# Memorandum

**Date:** March 22, 2016

**Re:** **March 22, 2016 Planning Board Hearing**  
**PROPOSED ADDITIONAL SITE PLAN CONDITION OF APPROVAL**  
Level III Subdivision and Site Plan:  
Redevelopment to create 4 residential units, 31 Fore Street  
Bob and Carrie LeBlanc, Peninsula Property Development, Applicants

1 FLOOR PLAN - GARAGE/BASEMENT
 SCALE: 1/4" = 1'-0"

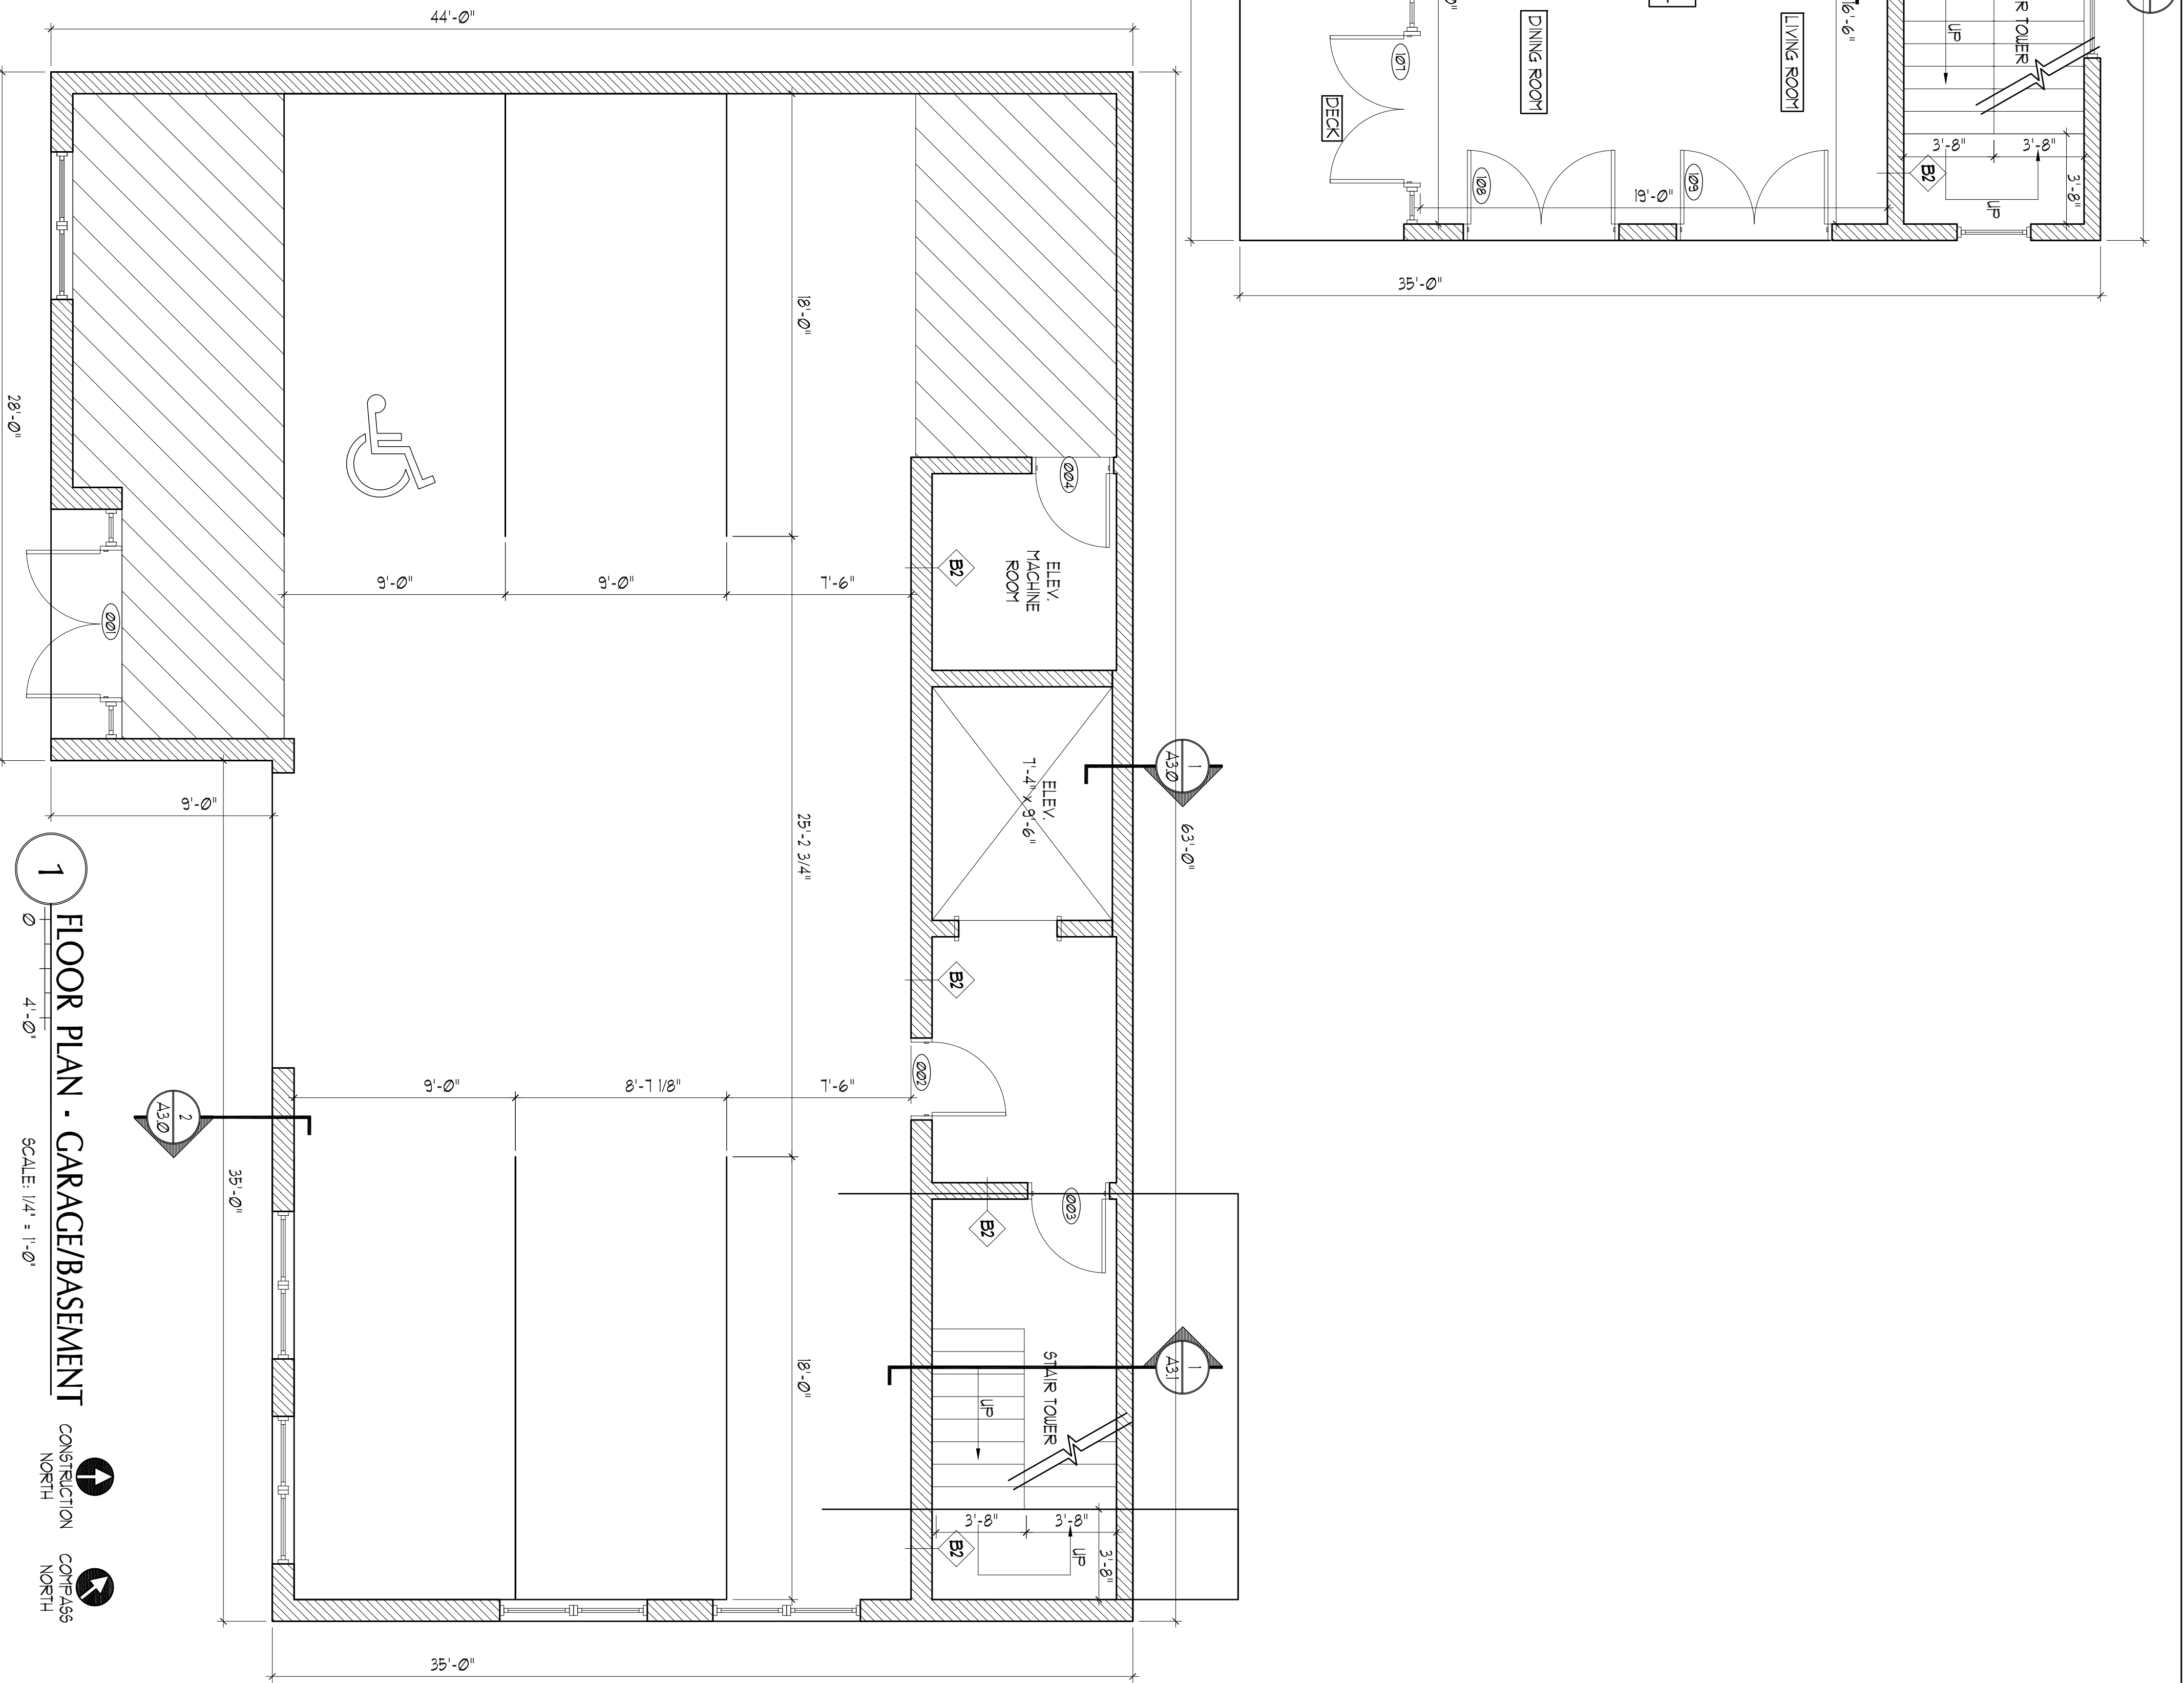
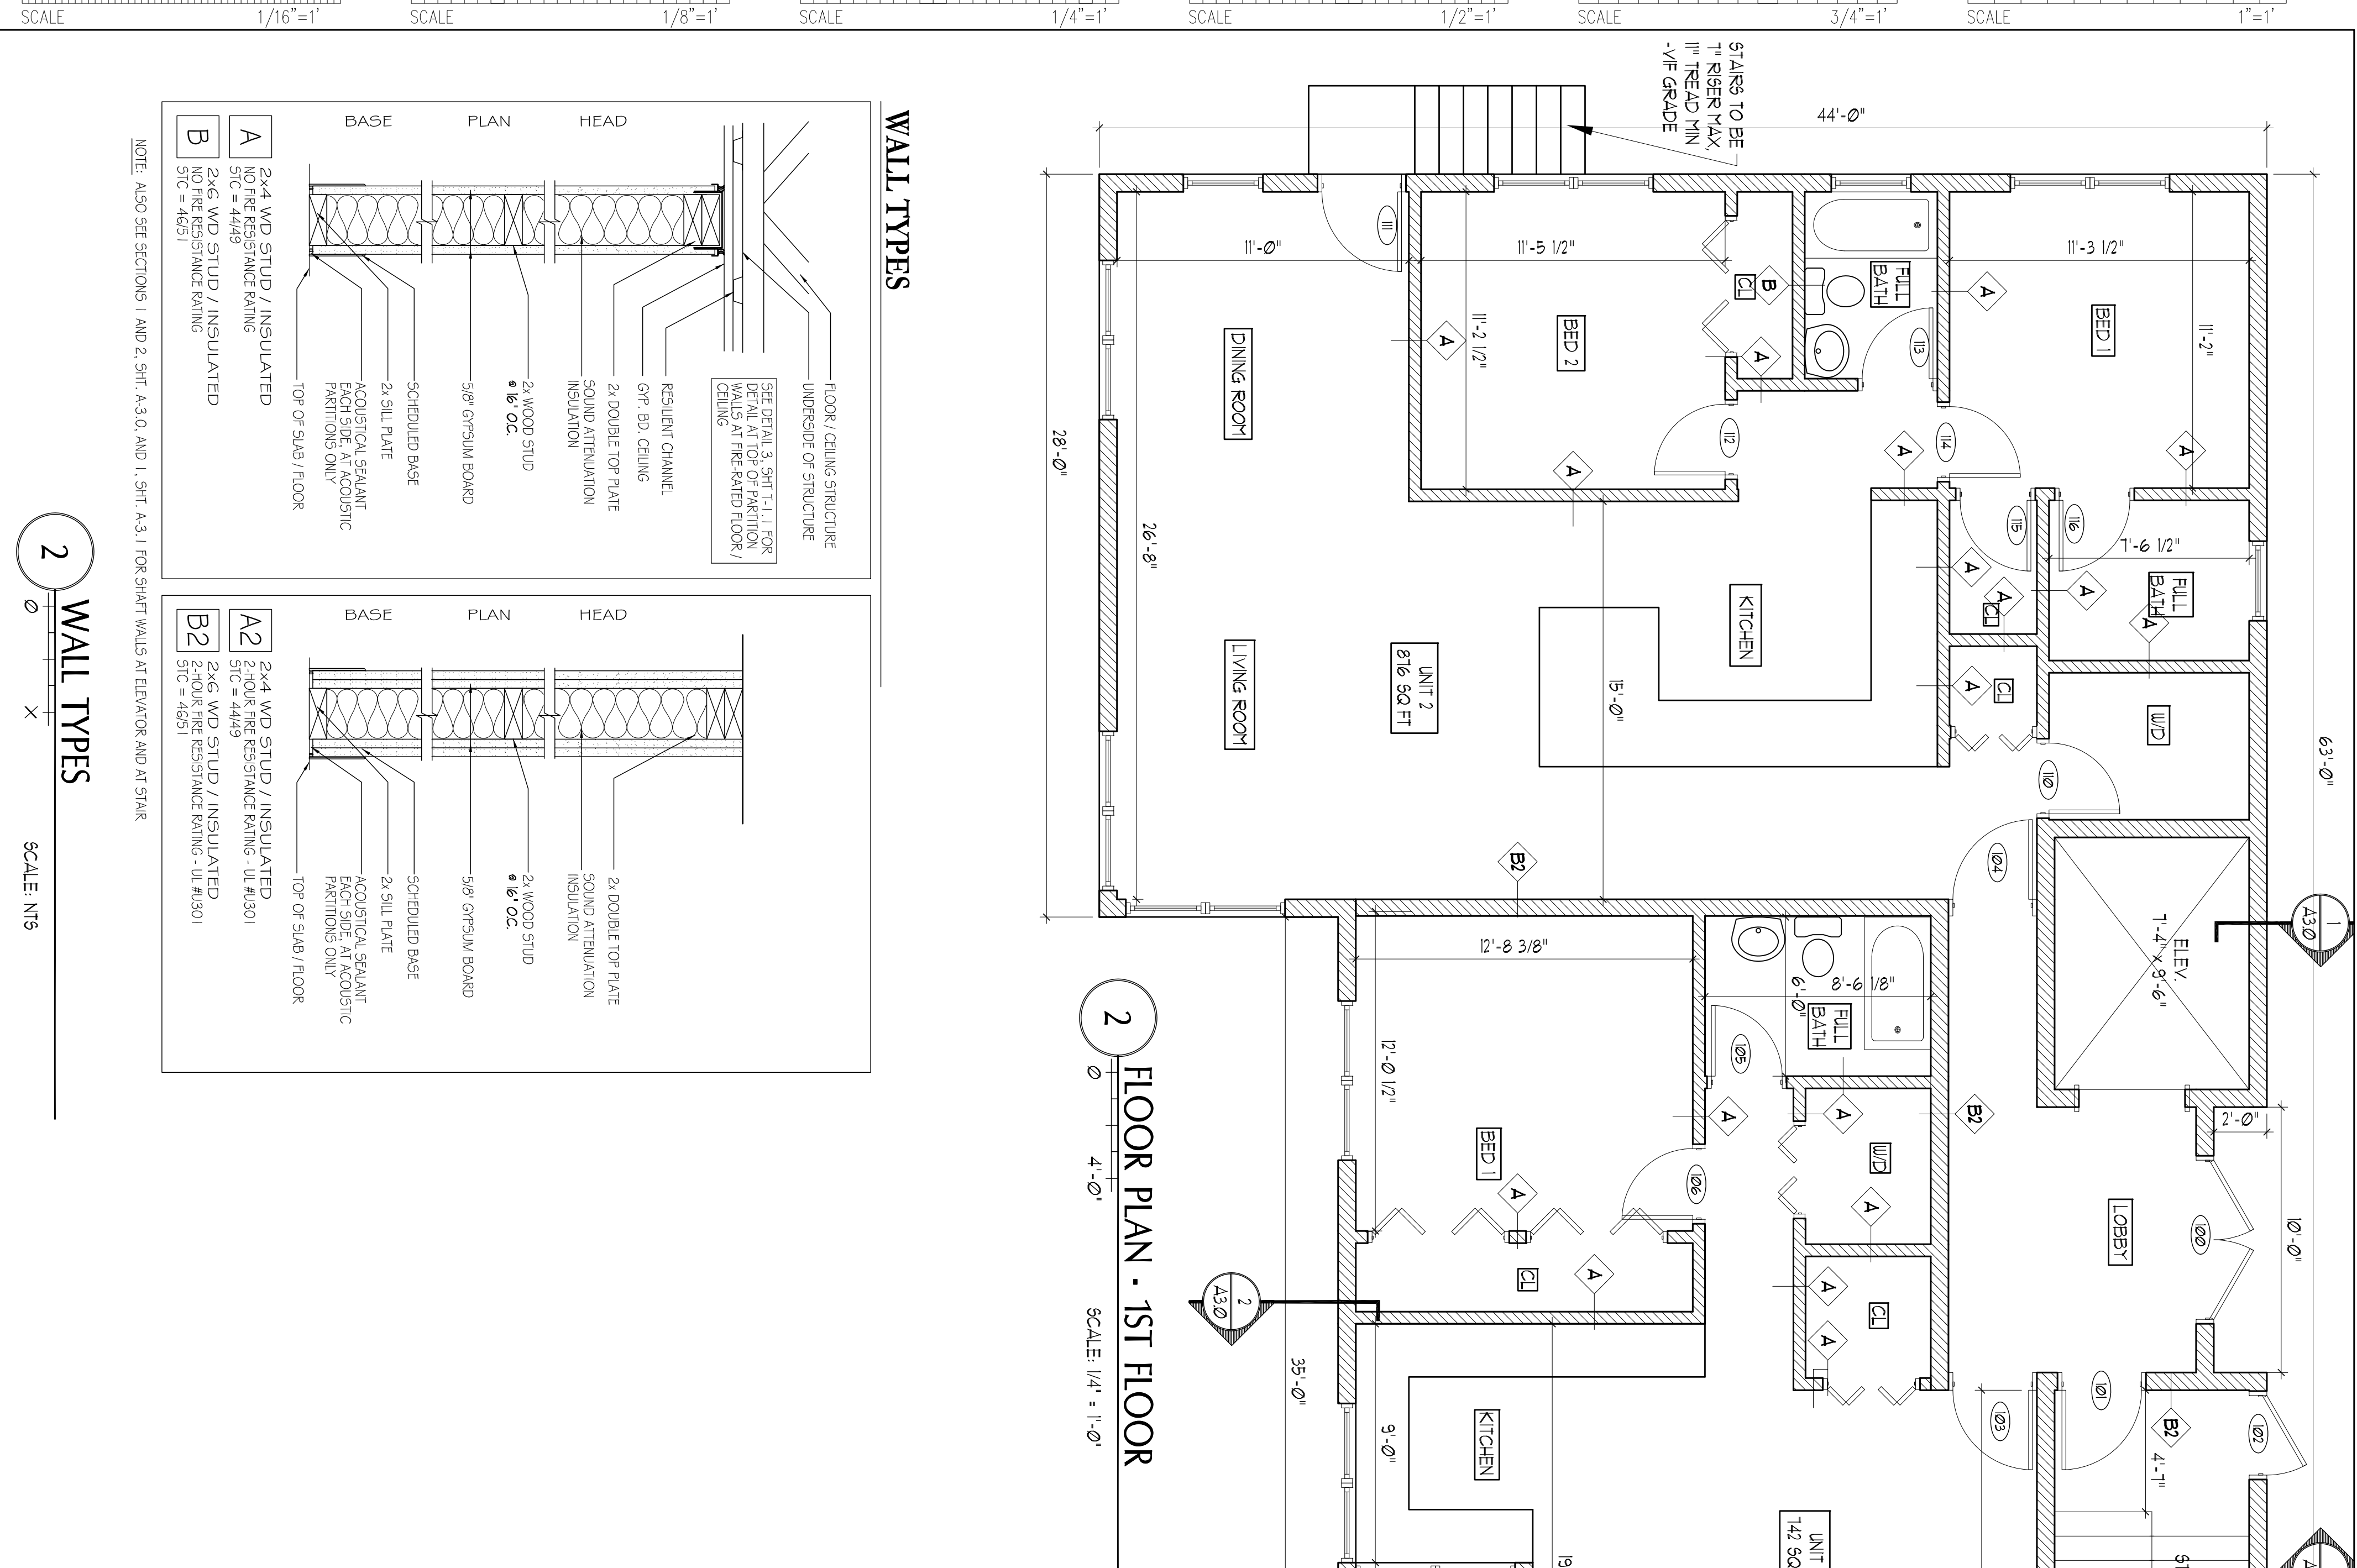
Since preparing the PB Hearing Report for this project, staff have noted that the proposals do not clarify how the parking layout meets the Fair Housing Act requirement for one ADA accessible parking space within the parking garage. The accessible access (from Waterville Street) enters the garage near a parking space and leads to the elevator, but the extra access aisle beside an ADA space has not been shown in the layout of the parking spaces (Plan P4 and P9).

Staff recommend that an additional condition be considered that requires the parking spaces to be reconfigured to allow one of the spaces to meet the ADA Fair Housing Act requirements.

The six spaces as shown in the plans are all of standard size with a wider than required drive aisle; the zoning requirement for this development would be one parking space. Additional space for an ADA access aisle could be made available by reducing the width of the parking aisle; converting up to 2 spaces to be compact size; reconfiguring the storage space; and/or reducing the overall number of spaces.

*vii. That the applicant shall submit a revised parking layout within the parking garage to show an ADA compliant parking space, for review and approval by the Planning Authority prior to the issuance of a building permit. The applicant may convert up to 2 spaces to be less than standard size and may reduce the number of parking spaces to meet this requirement, subject to meeting zoning requirements and satisfying the Traffic Engineer regarding operation.*
